**KIRKLEES METROPOLITAN COUNCIL
INVESTMENT & REGENERATION SERVICE**

DELEGATED DECISION TO DETERMINE APPLICATIONS FOR LISTED BUILDING CONSENT

Reference No:	2024/65/91502/W
Site Address:	2, The Old Stables, Huddersfield Road, Meltham, Holmfirth, HD9 4BQ
Description:	Listed Building Consent for replacement windows and doors
Recommending Officer:	Sebastian Pickles

DECISION – CONSENT GRANTED

Window Section

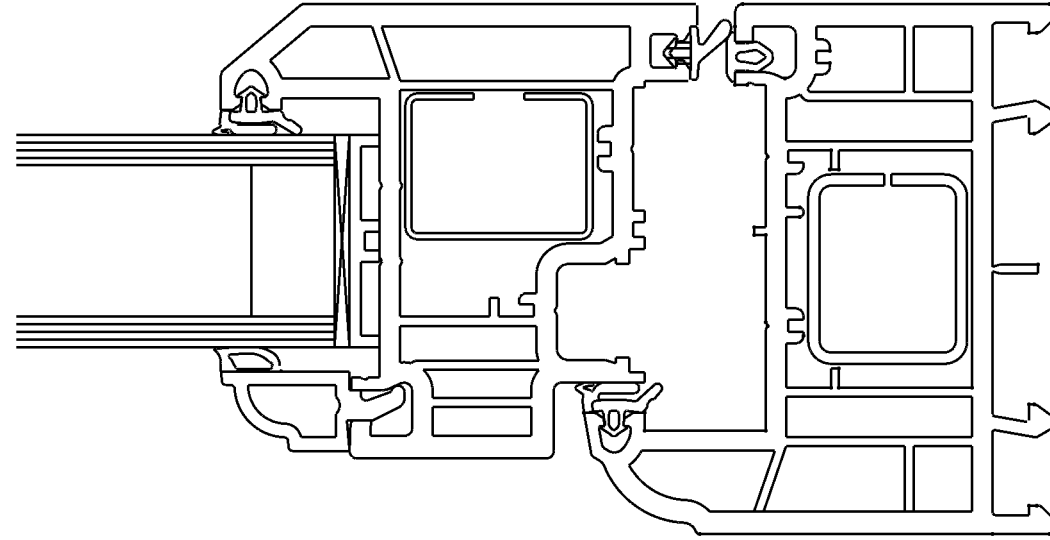
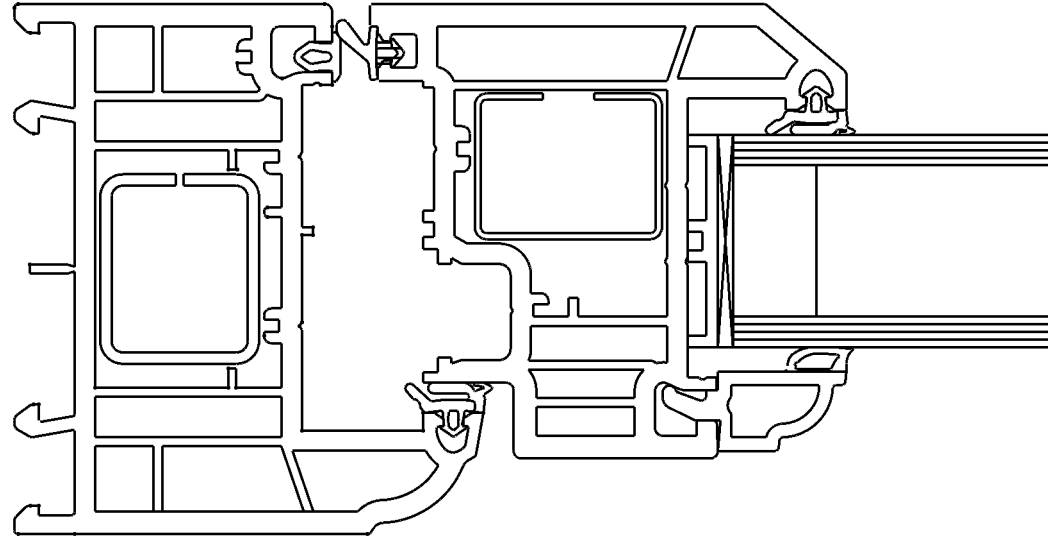
The proposals under the application are for the replacement of the existing windows and doors from the existing timber windows to aluminium frames and doors.

The existing windows appear to have been added at the time of its conversion around 2006 and are of no historic merit. The intention as shown on the plans is to retain the configuration of the windows to the front elevation. There will however be one change. The existing top windows are fixed, however, with the replacement windows, these will be top-opening casements. The replacement windows will be flush fitting, which is a small improvement from the existing windows. The replacement doors will be a match in design to the existing, the only change being that they will be constructed in aluminium.

The colour of the windows and doors has been agreed to be Slate Grey. While there is a change of materials, the form of the replacement windows and doors will retain the character and appearance of the building and with the history of the building, the use of metal frames is considered reasonable.

3. Notwithstanding the submitted details all replacement windows and doors shall be finished in Slate Grey (RAL No. 7015) unless otherwise agreed in writing by the LPA.
